# THE VICTORIAN SOCIETY

Your reference: 2023/65/90112/E  
& 2023/62/90024/W

21<sup>st</sup> February 2023

**RE: Listed Building Consent for partial demolition of Listed Building to facilitate refurbishment and extension of the George Hotel to form 90+ room C1 hotel with associated ancillary uses (including bar, restaurant, gym, conference room) (within a Conservation Area)**

Sheet Name: Proposed GEA

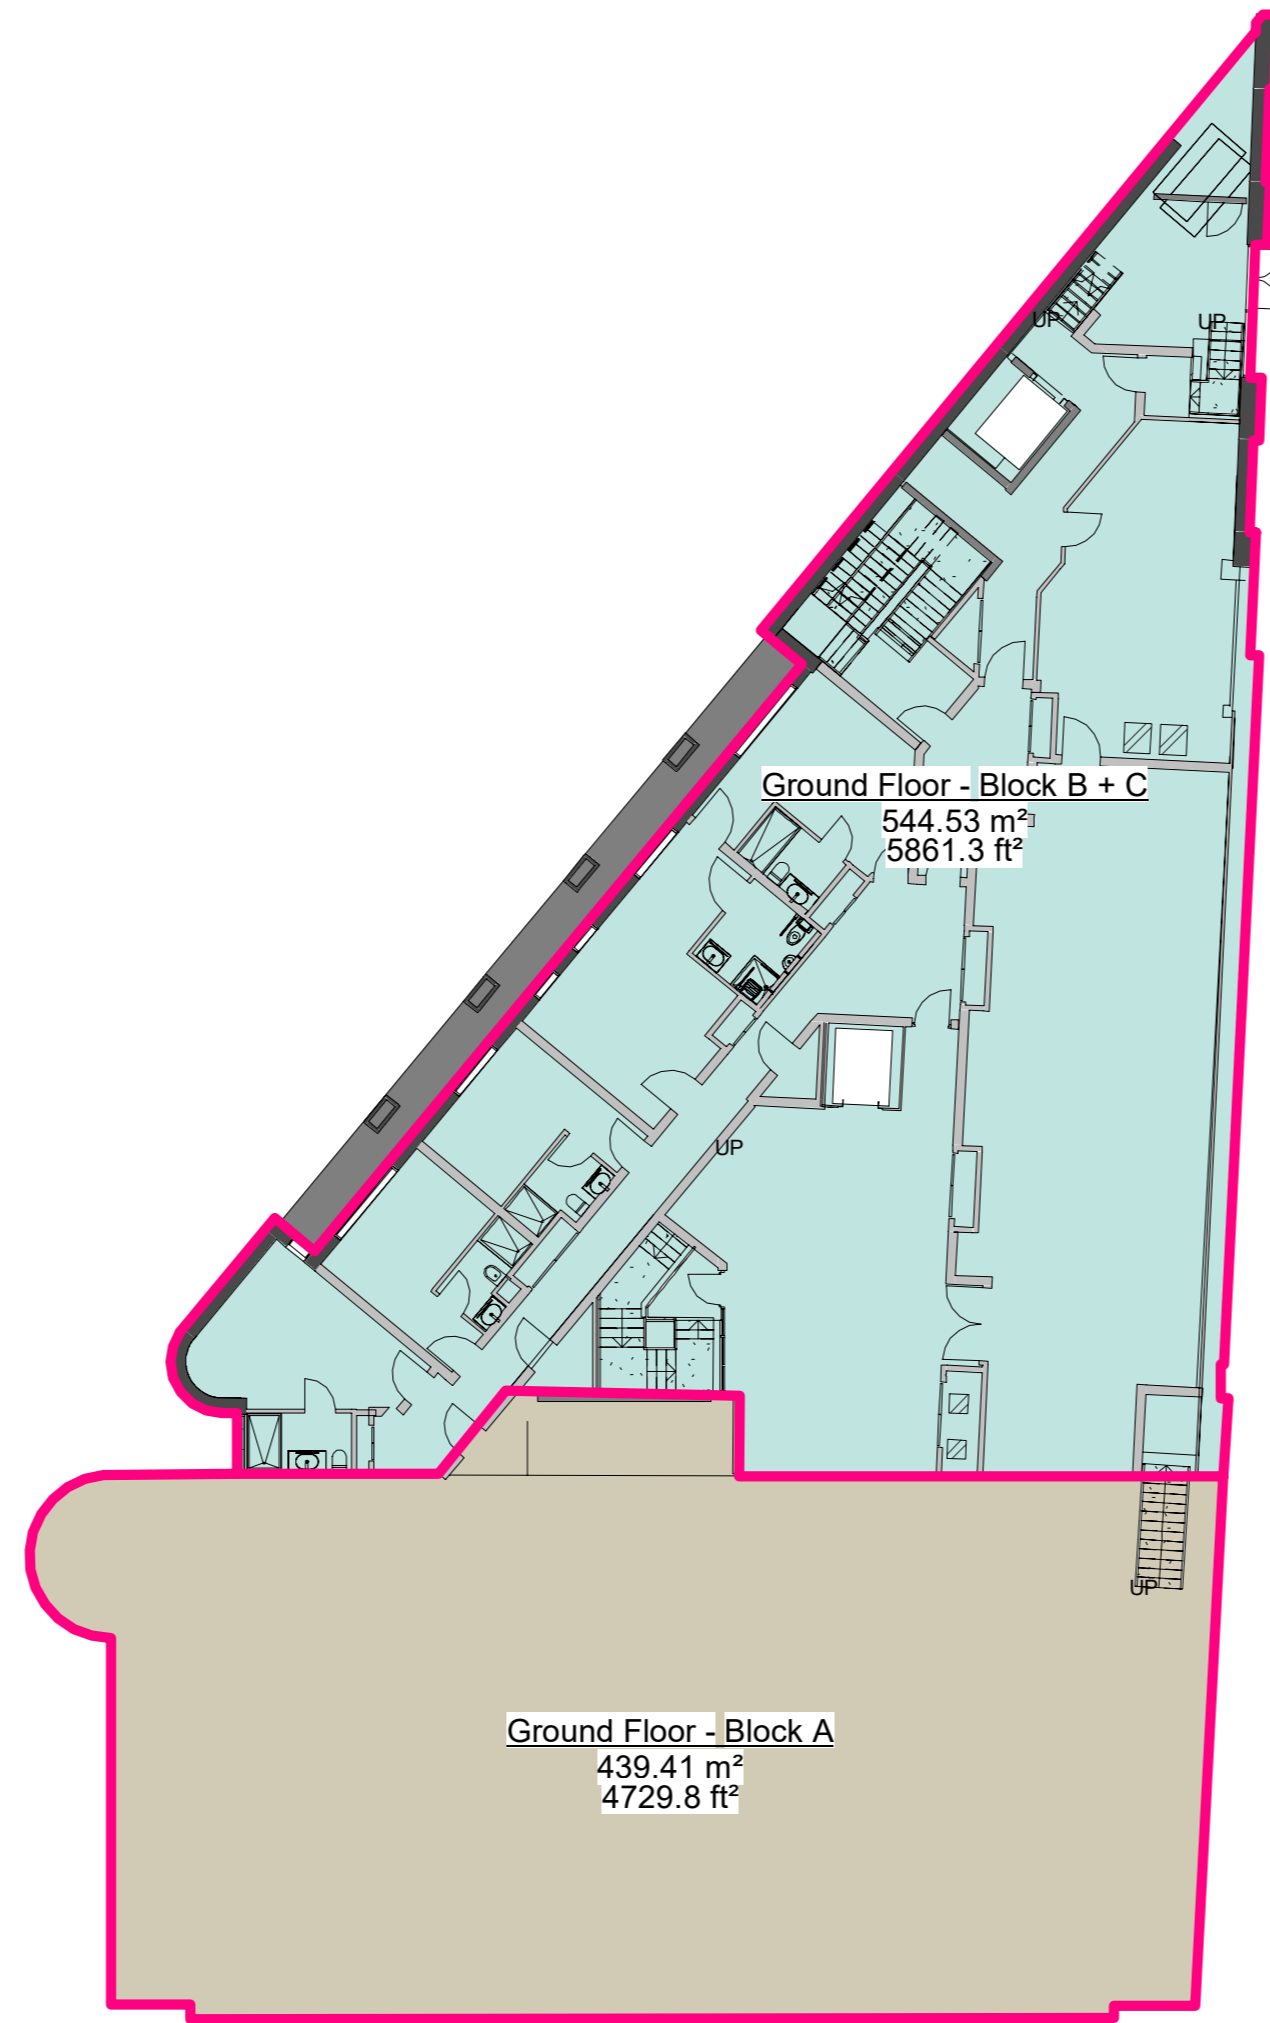
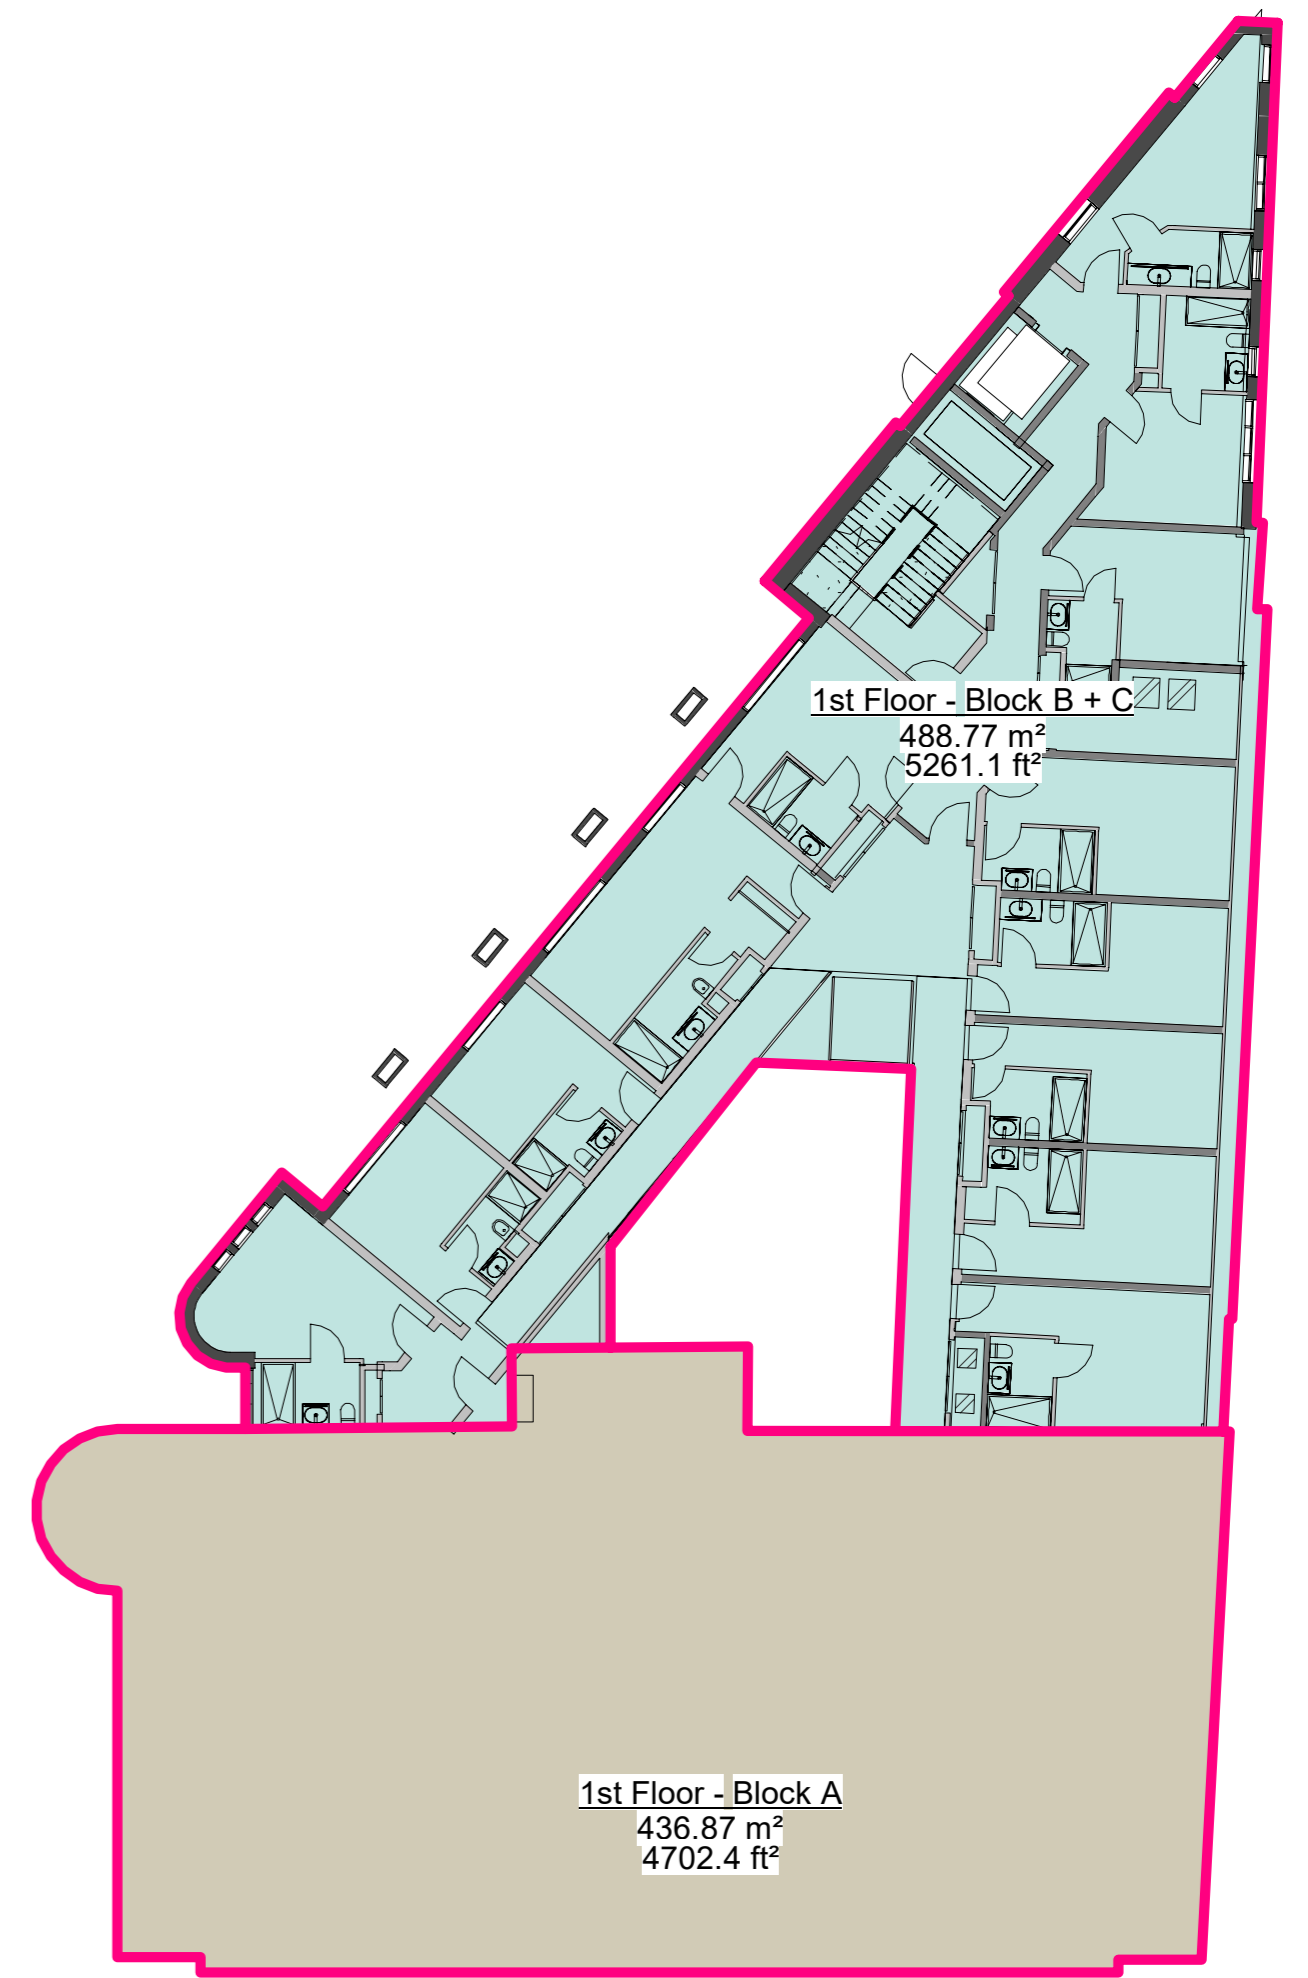
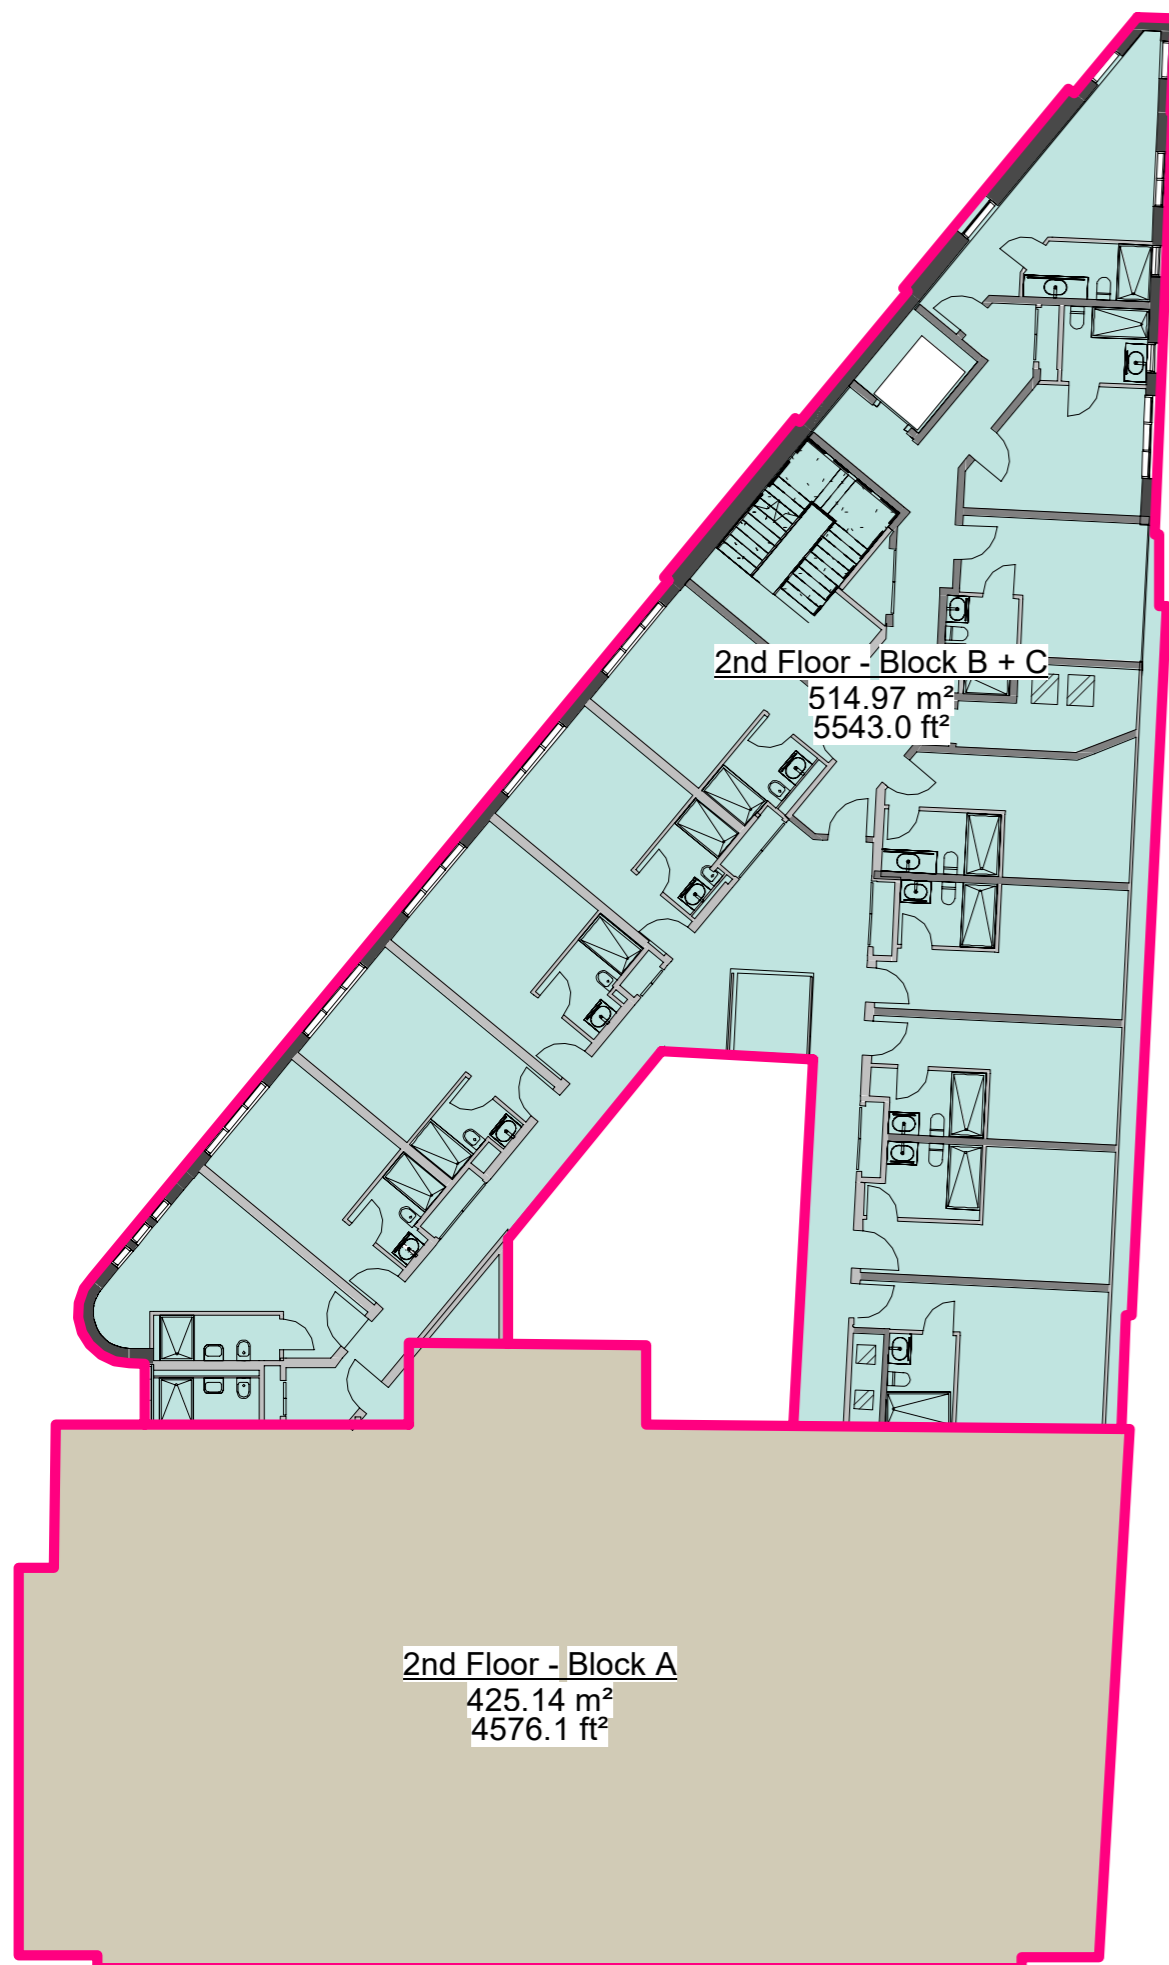
Thank you for consulting the Victorian Society about this application. We **object** to the proposed demolition of the North West wing, partial demolition of the East wing and additional 3 storey extension.

The proposed massing of the extension which would replace the NW wing and most of the E wing is too large. It would overwhelm the careful classical proportions of the principal block and the surviving façade on John Williams Street. The immediate conservation area is characterised by classically proportioned buildings, a hallmark of classical architecture, with the exception of pediments or domes, is a flat roof. Buildings from this period in the design are often built with discrete mansard dormers that disappear or are non-intrusive at street level.

The massing of the proposal would be visually jarring and greatly distract from the carefully executed classical design of the hotel and neighbouring heritage assets. Furthermore, given the grade II\* status of this building and the group value of this area, it is surprising that the design of this extension is so poor and low quality. The massing and design of the proposed extension would cause substantial harm to this heritage asset and less than substantial harm to the Huddersfield Town Centre Conservation area.
